**Preliminary Arborist Report
DRAFT**

To: JMK Homes c/o Jed Murphy
Site: 6610 E Mercer Way, Mercer Island, WA
Re: Tree inventory
Date: April 21st, 2022
Project Arborist: George White,
ISA Certified Arborist #PN-8908A
ISA Qualified Tree Risk Assessor
Reviewed By: Joseph Sutton-Holcomb
ISA Certified Arborist #PN-8397AM
Municipal Specialist, ISA Qualified Tree Risk Assessor
Referenced Documents: Topographic Survey (Pace Engineers, 6.6.2018)
Koneru Short Plat (Pace Engineers, Revised 4.12.2022)
Attached: Table of Trees
Tree Site Map

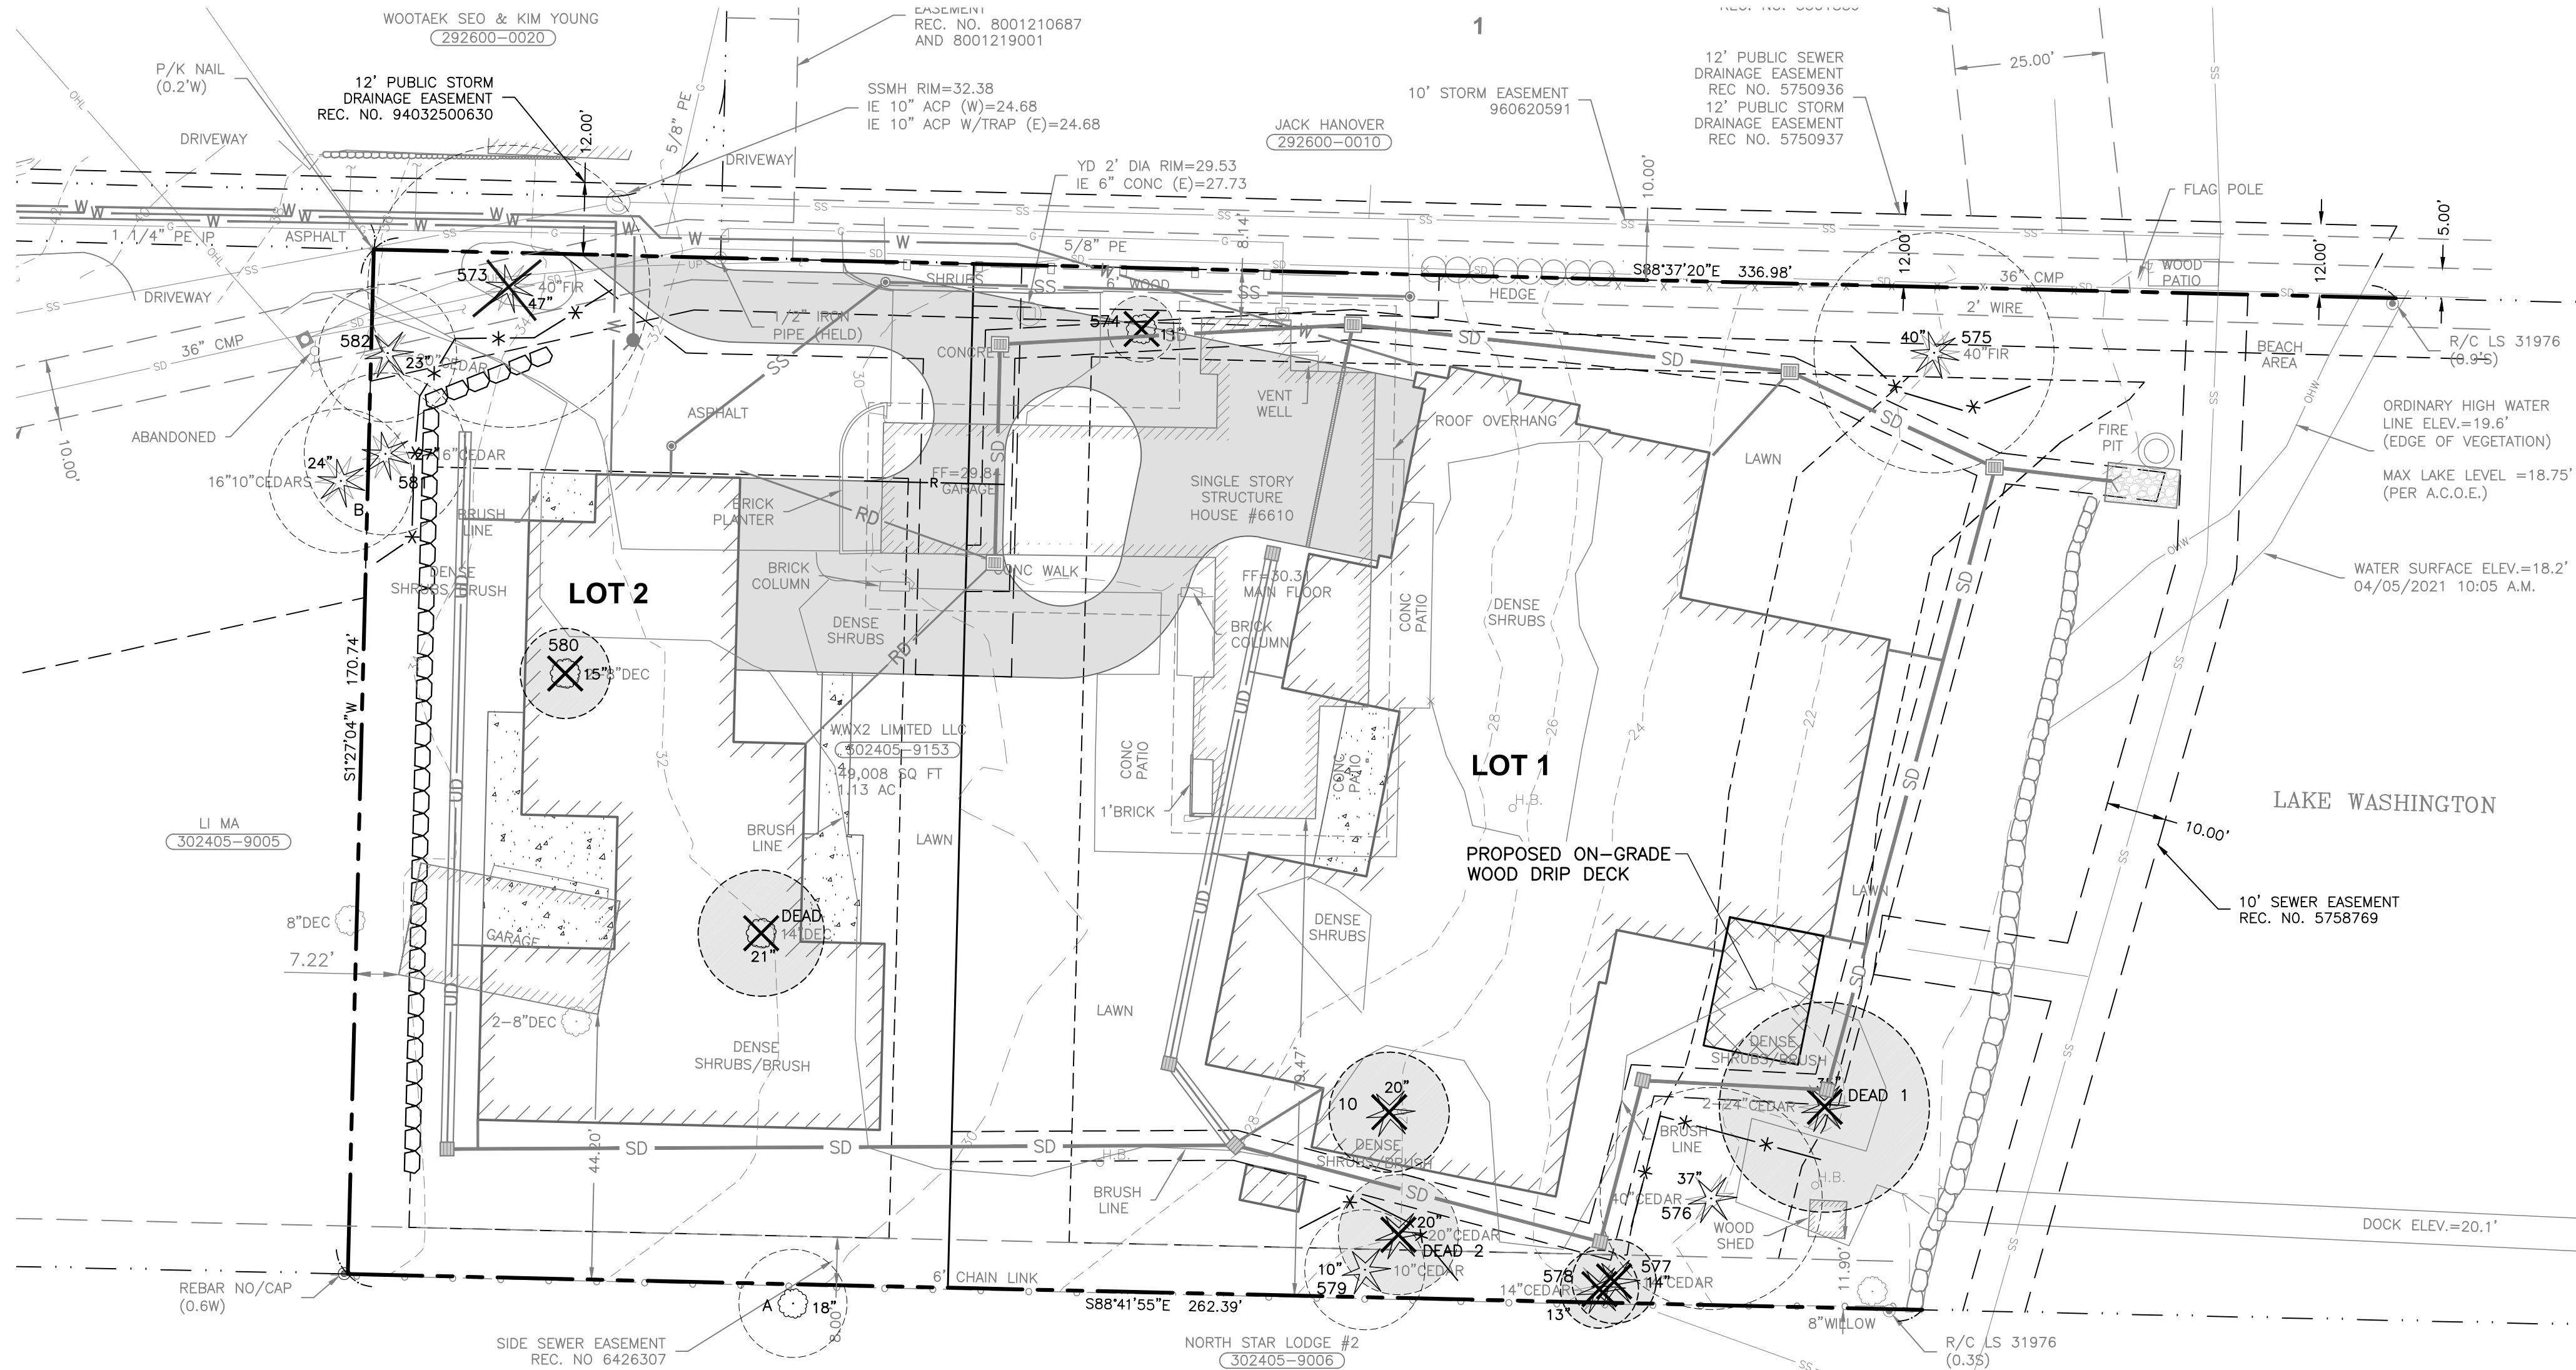
- Update tree protection plan sheets to include the RLOD, Minimum Limits of Disturbance (MLOD) and tree protection fencing using the data from the attached table of trees.

- Tree protection fencing on the plan set must be expanded to encompass the entire tree protection area for retained trees.
- Obtain all necessary permits and approval from the city prior to commencement of site work.
